Address: 201 Woodlands Road Batley wf17 0re

Application number: 2020/94203	
What is the application for?:	Outline application for demolition of dwelling and associated outbuildings and t
Address of the site or building:	Clough House, 236, Leeds Road, Birstall, Batley, WF17 0HW
Postcode:	YO26 8EW

Type of comment: An objection
<p>Hello there</p> <p>I live in the locality of the proposed development, about a a mile away. However I have family - that live at Moat Hill Farm Drive. I am a regular caller, helping with their garden, and taking my grand daughter for walks Post Covid 19 I will probably visit more frequently. However, I know the location very well. Unlike many who illustrate a NIMBY trait, I do not disagree with the proposed development per se. I understand the need for additional housing, and the pressure on the Council to provide it. However the access issue does concern me.</p> <p>I note the proposed development comprises 30 houses, and provision for a maximum of 70+ cars. This takes the form of 2 unconnected culs de sac -23 houses at the upper end of the development and 7 houses nearer Leeds Road. I know through social media that many local people are concerned that the

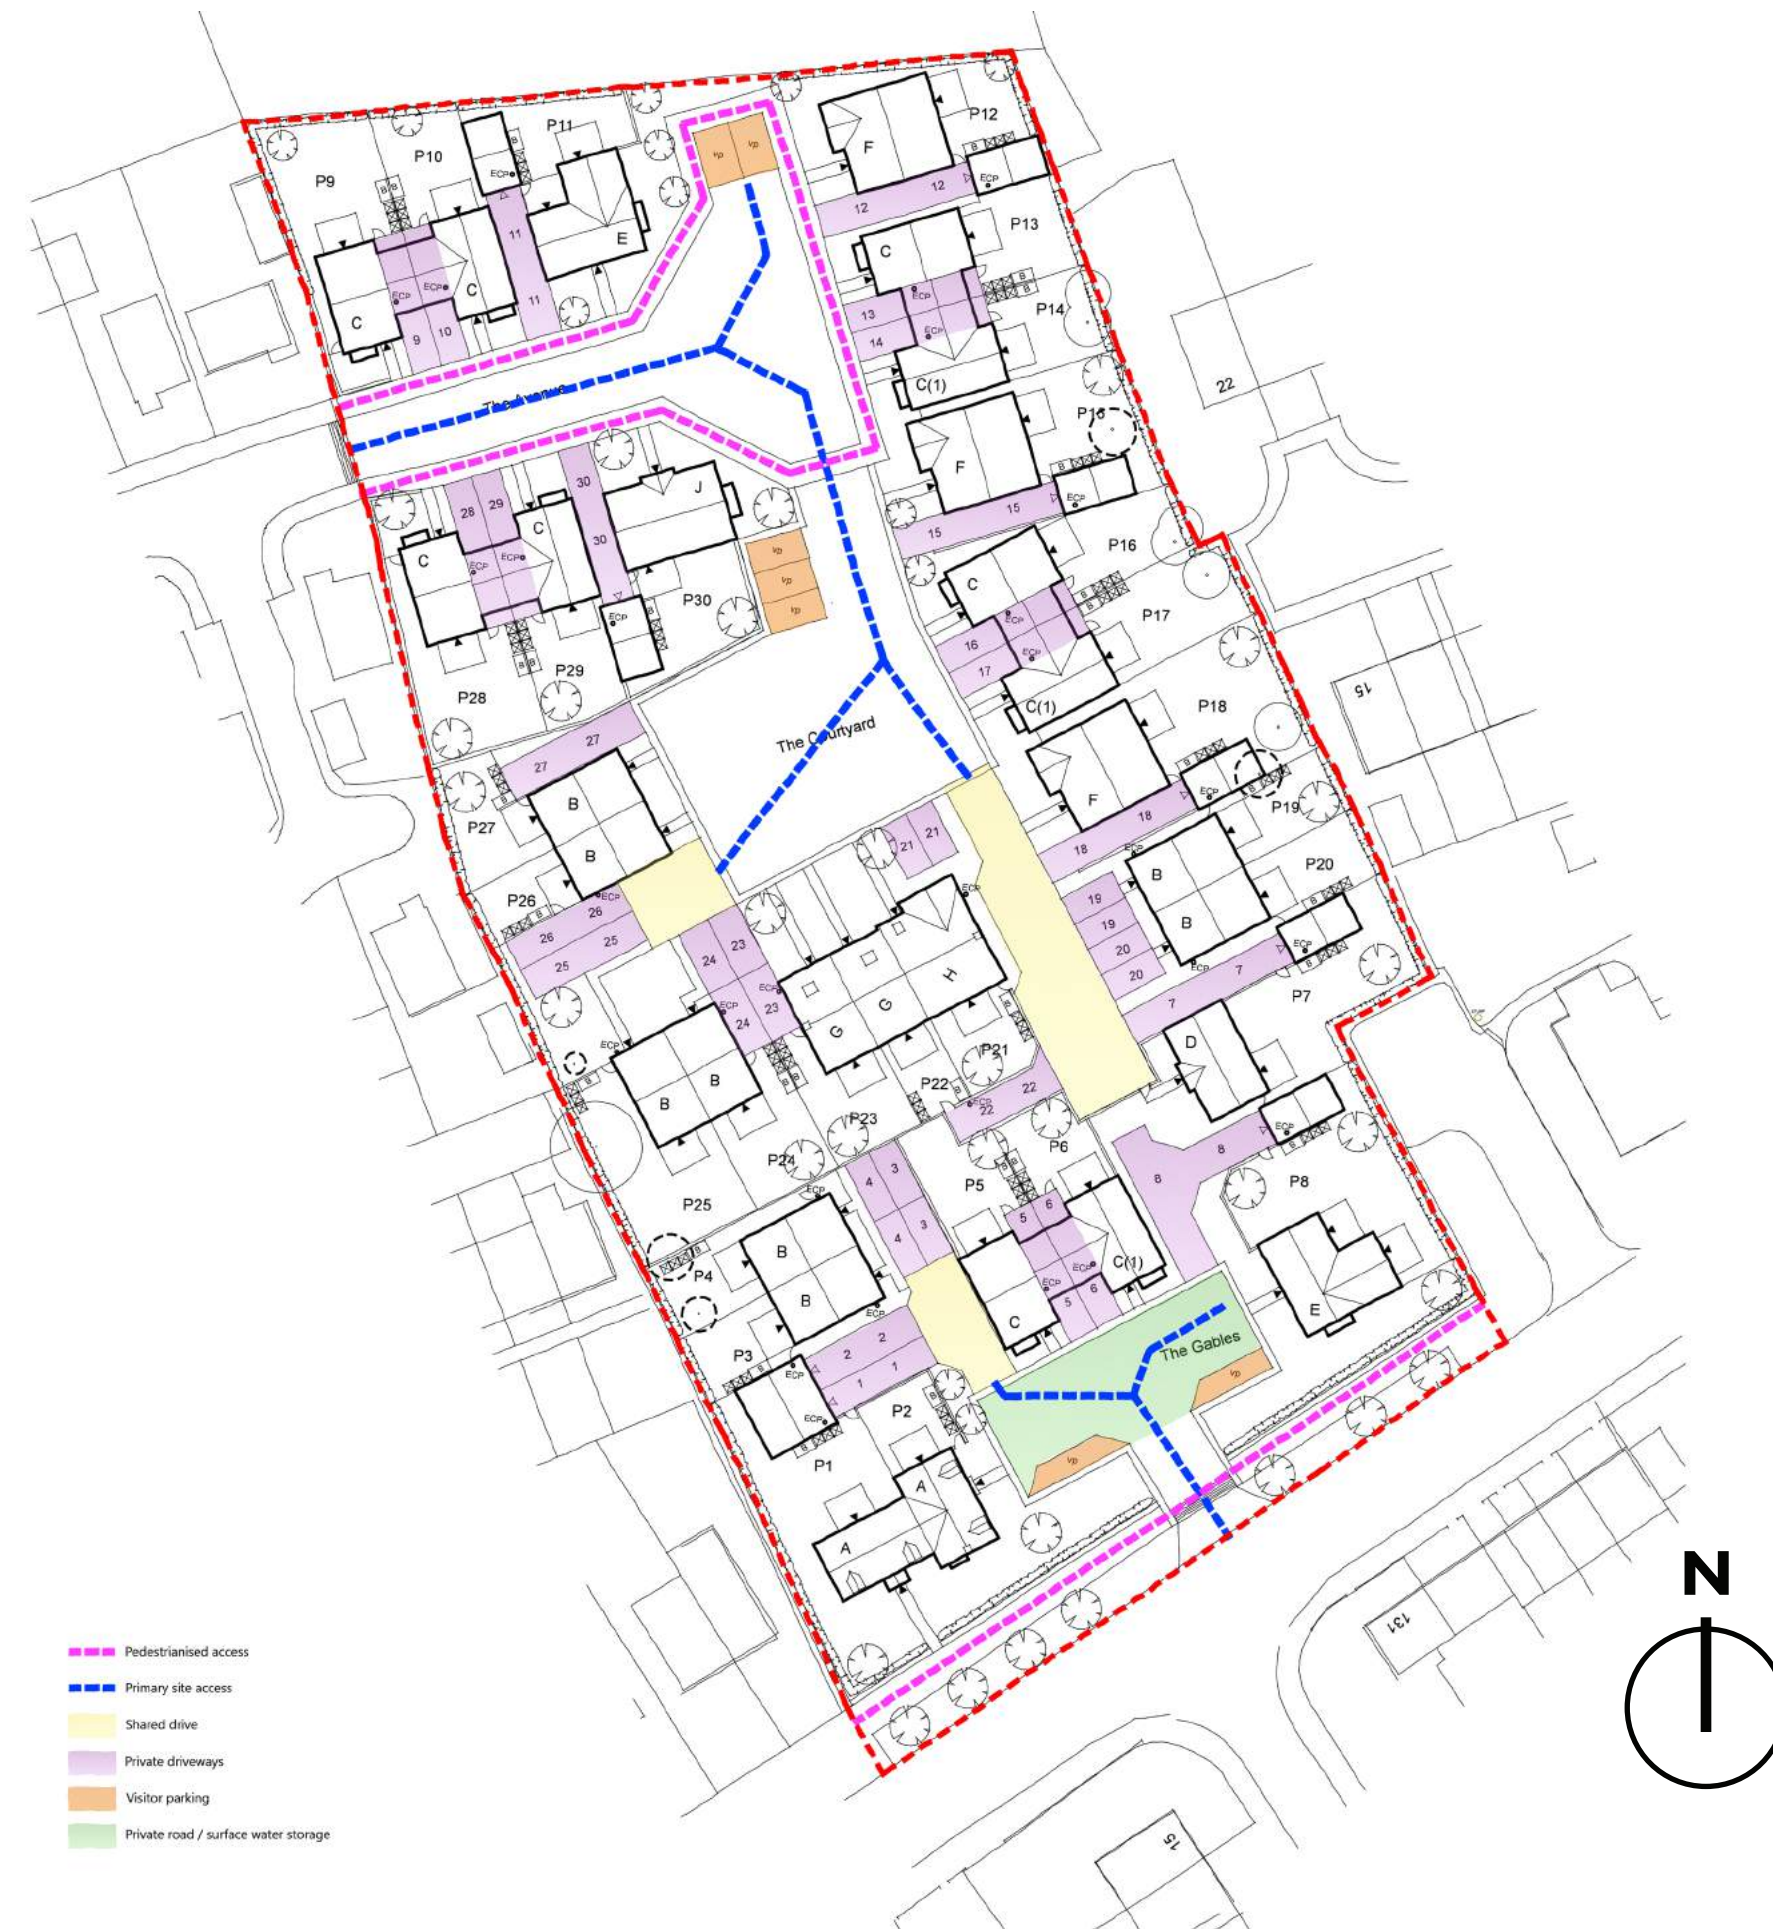
4. There are currently 50 housing units that utilise access from Moat Hill Farm Drive to Leeds Road. The proposed development layout would increase this number to 73 (ie an additional 23 units). Surely maintaining 50 from Moat Hill Farm Drive, and the 30 from the new development accessing directly on to Leeds Road (rather than through Moat Hill Farm Drive) would be a better balance of traffic management ?

5. The proposal is principally for 2 culs de sac - 23 houses at the top end of the site and 7 houses at the lower end adjacent to Leeds Road. If Outline Permission was to be granted, could consideration be given to the culs de sac split on the new development preferably be 7 houses at the top end, and 23 houses adjacent to Leeds Road This would at least reduce traffic along Moat Hill Farm Drive, and be something of a compromise solution for local residents.
